Your Ref: OWPC4154
Our Ref: AB/115/14/OUT 17-09-2014
Please ask for:
Mr D Sullivan

Outline application with some matters reserved for 2No. 3 bed semi detached houses
12 & 14 Canada Road Arundel

Thank you for your internet representation made on 27th October 2014 which has been recorded as '**an objection**' with the comments as follows:

Drg Title: SITE PLAN		Drg No: 14/1950/S01
Client:	Location:	Rev: A
MR SCODFREY	12-14 CANADA ROAD	Scale: 1:200 (A3)
	ARUNDEL	Drawn by: JSW

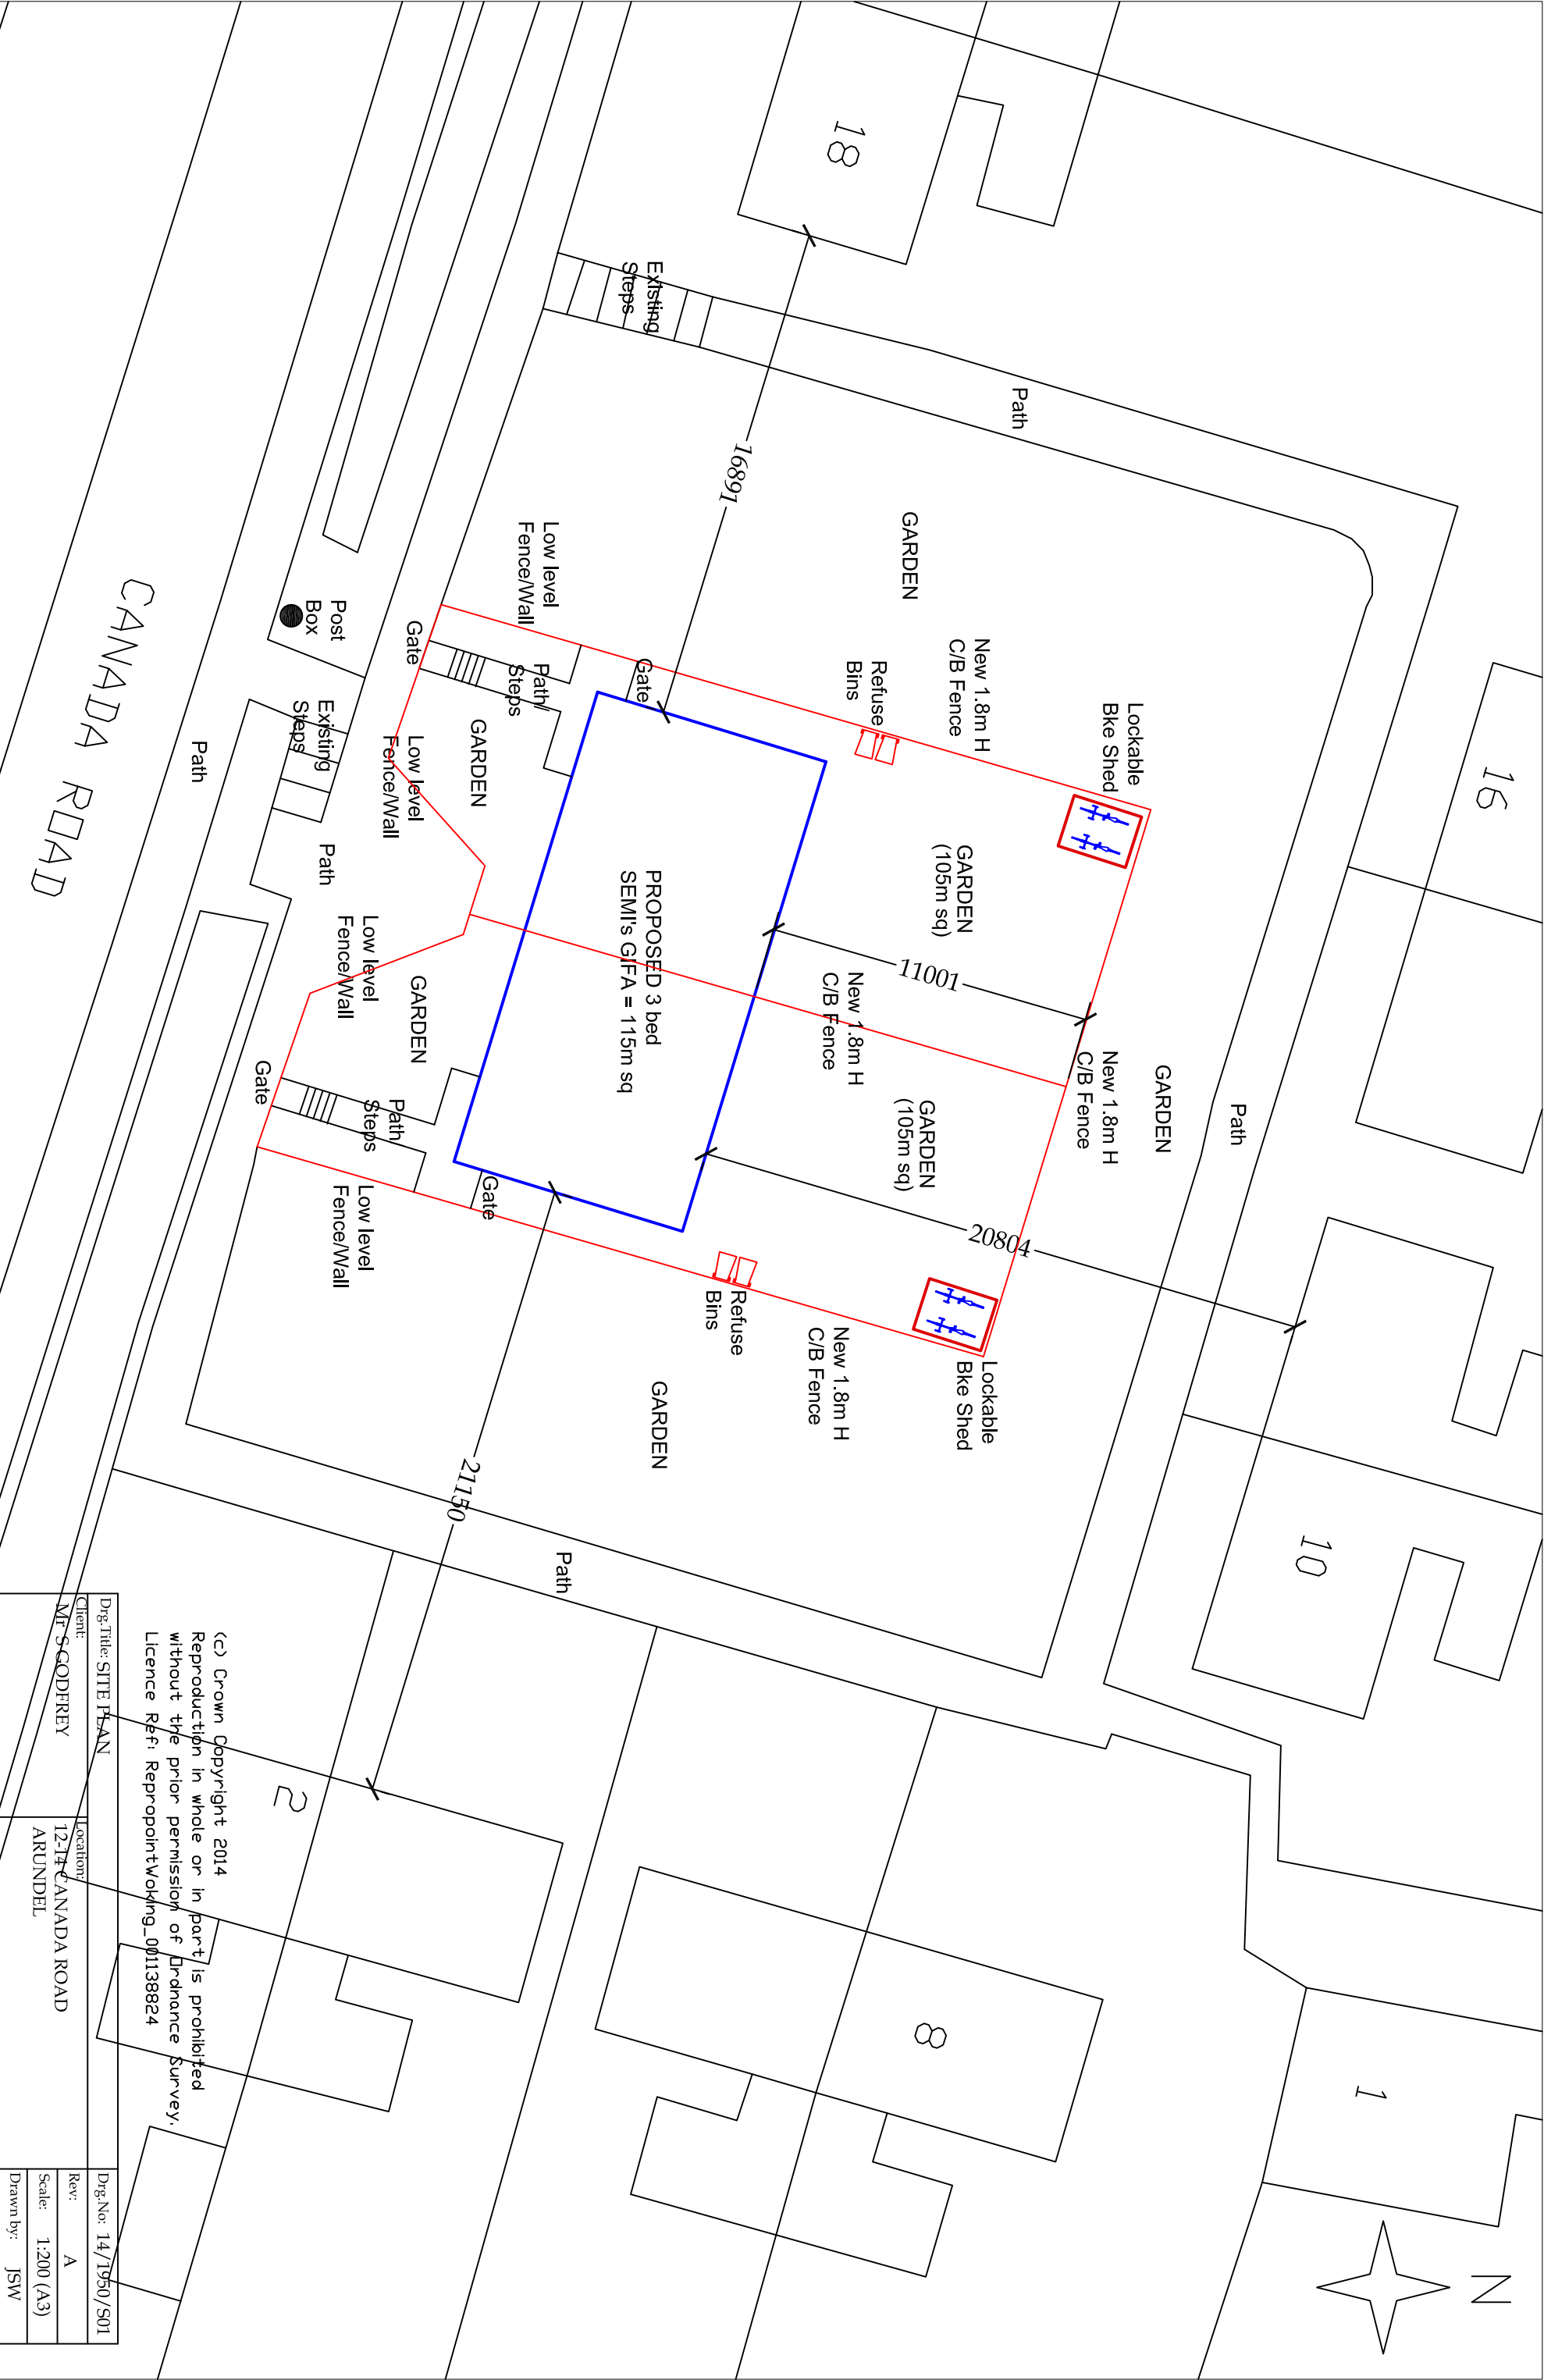
I believe the Planning Application has been filled in incorrectly and wrongly states that there are no trees or hedges adjacent to the proposed building site. There are in fact trees in the garden of number 16 that are not all shown in the submitted photographs, and would be in close proximity to the proposed building area i.e. less than 20 metres away.

I have spoken to the Housing Department (Arun District Council) regarding the 'Parking Bays'. This land belongs to Housing and is not to be used for parking. The fence is only set back because on the day they erected it it was too muddy to put closer to the road, and they may move it back at some point. These areas are not to be used for parking.

I question the right of no's 12 & 14 to the use of the side pathways once the public/private? footpath to their properties has been built upon; leaving no access for 12 & 14 to their homes?

I bought my House i.e. no 18 as a sunny corner house, if this enormous building is built I will then become a house in a line of semi's and my home will be put in shade. That is not what I bought.

I believe the proposed would be an over development that would look ugly and change the character of the area.
